Alan Varela, Director

July 30, 2024

**RE: Caliber Collision – 250 98th ST NW
Erosion and Sediment Control Plan
Engineer's Stamp Date 3/7/24 (D17E008)**

CITY OF ALBUQUERQUE PUBLIC WORKS DIVISION ENGINEERING GROUP	
Caliber Collision EROSION CONTROL DETAILS	
DESIGN REVIEW COMMITTEE	CITY ENGINEER APPROVAL
LAST DESIGN UPDATE	MO./DAY/YR.
	MO./DAY/YR.
	MO./DAY/YR.
	MO./DAY/YR.
SHEET # 25 of 25

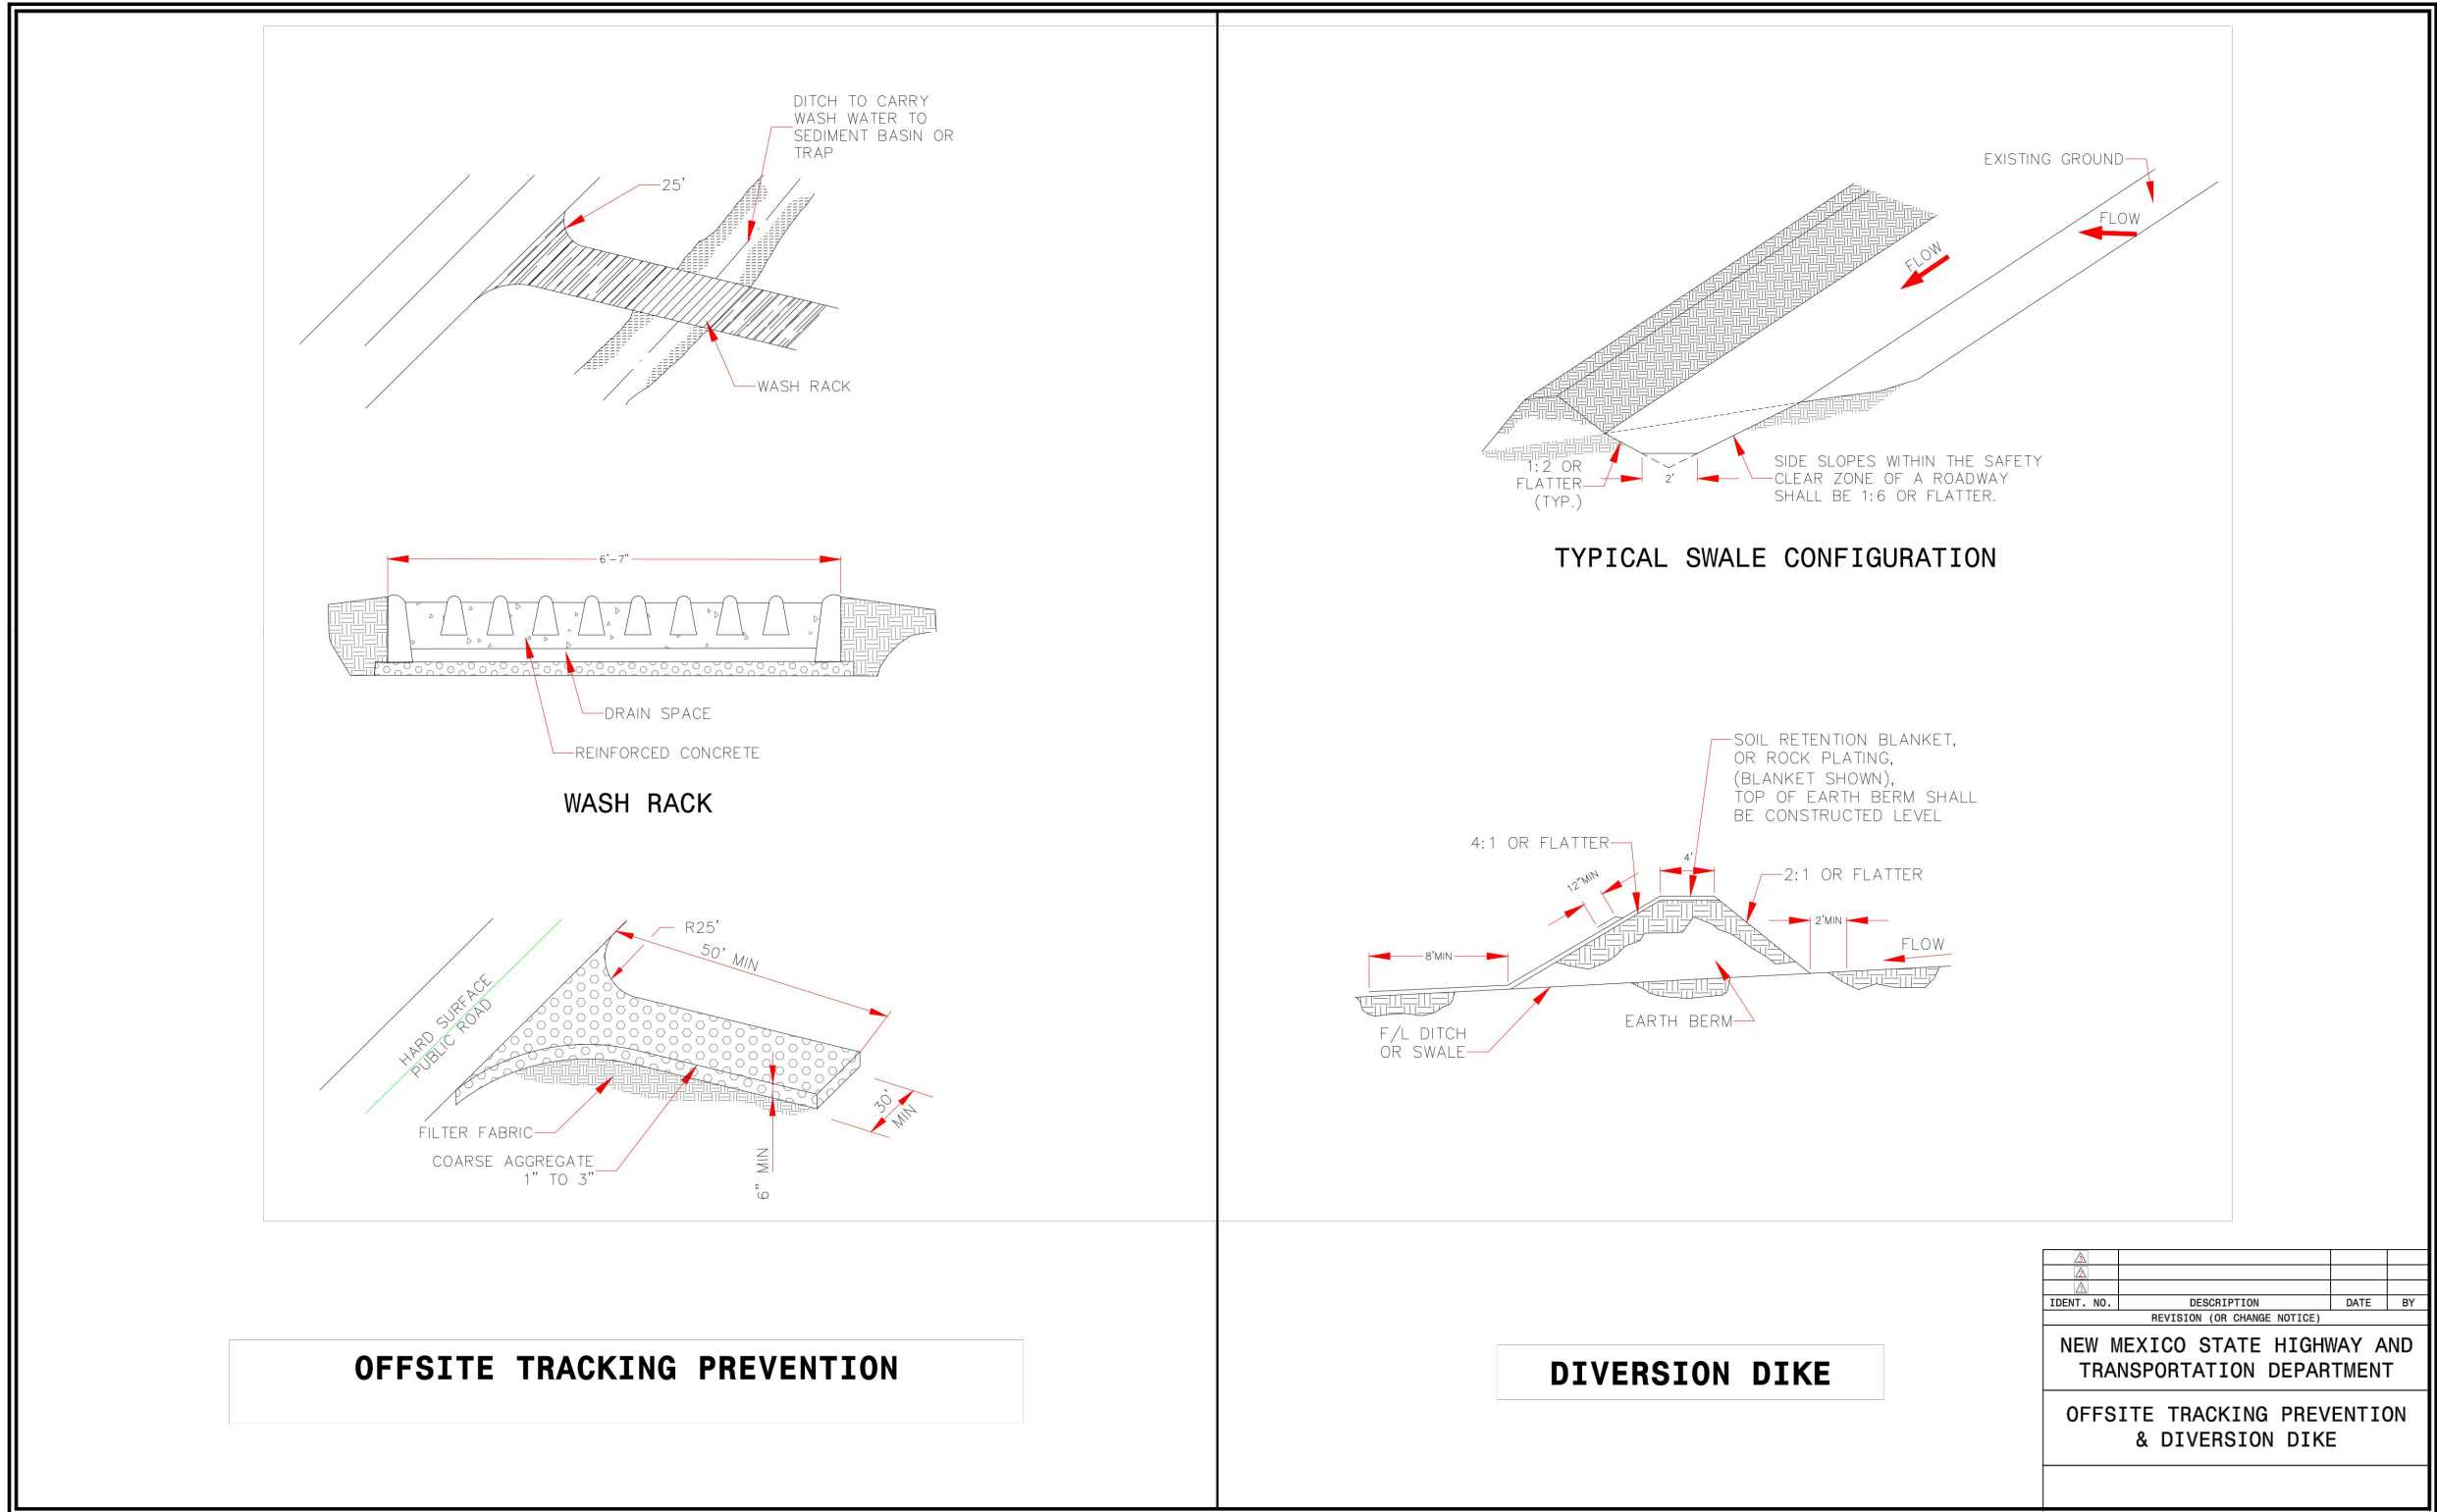
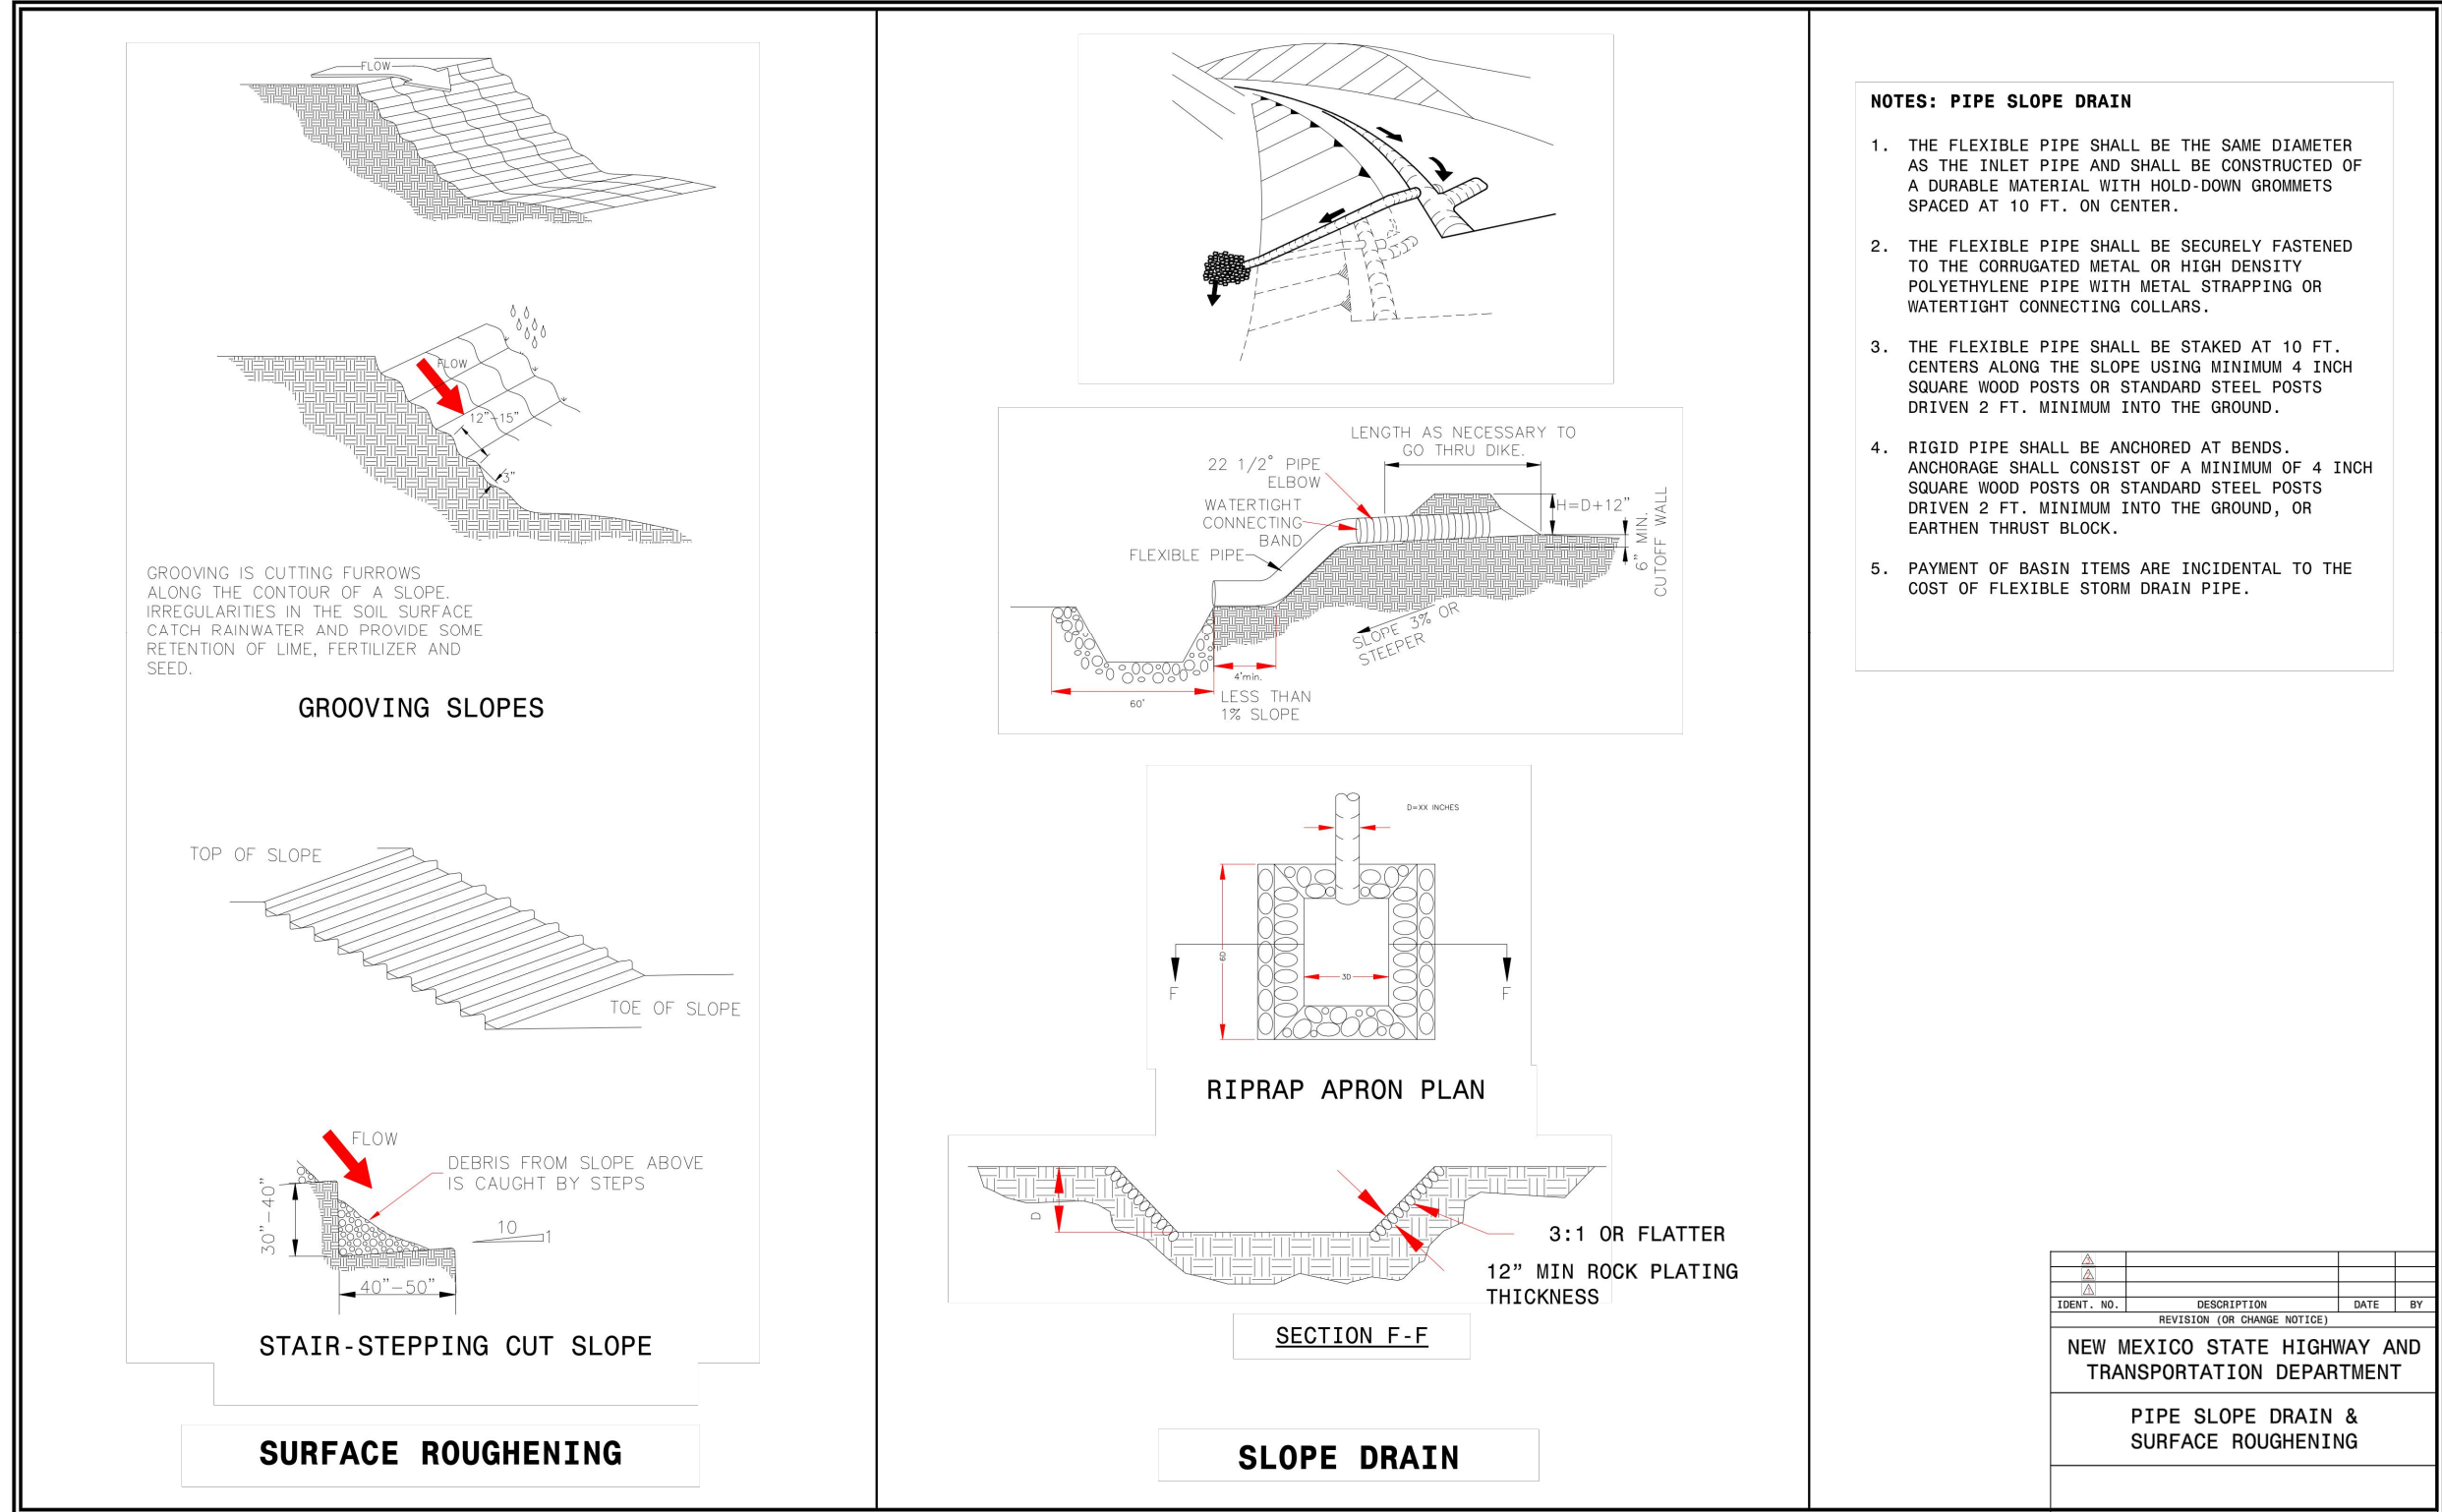
7. The Erosion and Sediment Control ESC Details are missing the construction, inspection, and maintenance specifications, as required by the city's ESC Plan Checklist and by CGP 9.6.1.c.i. *Erosion Control details provided.*
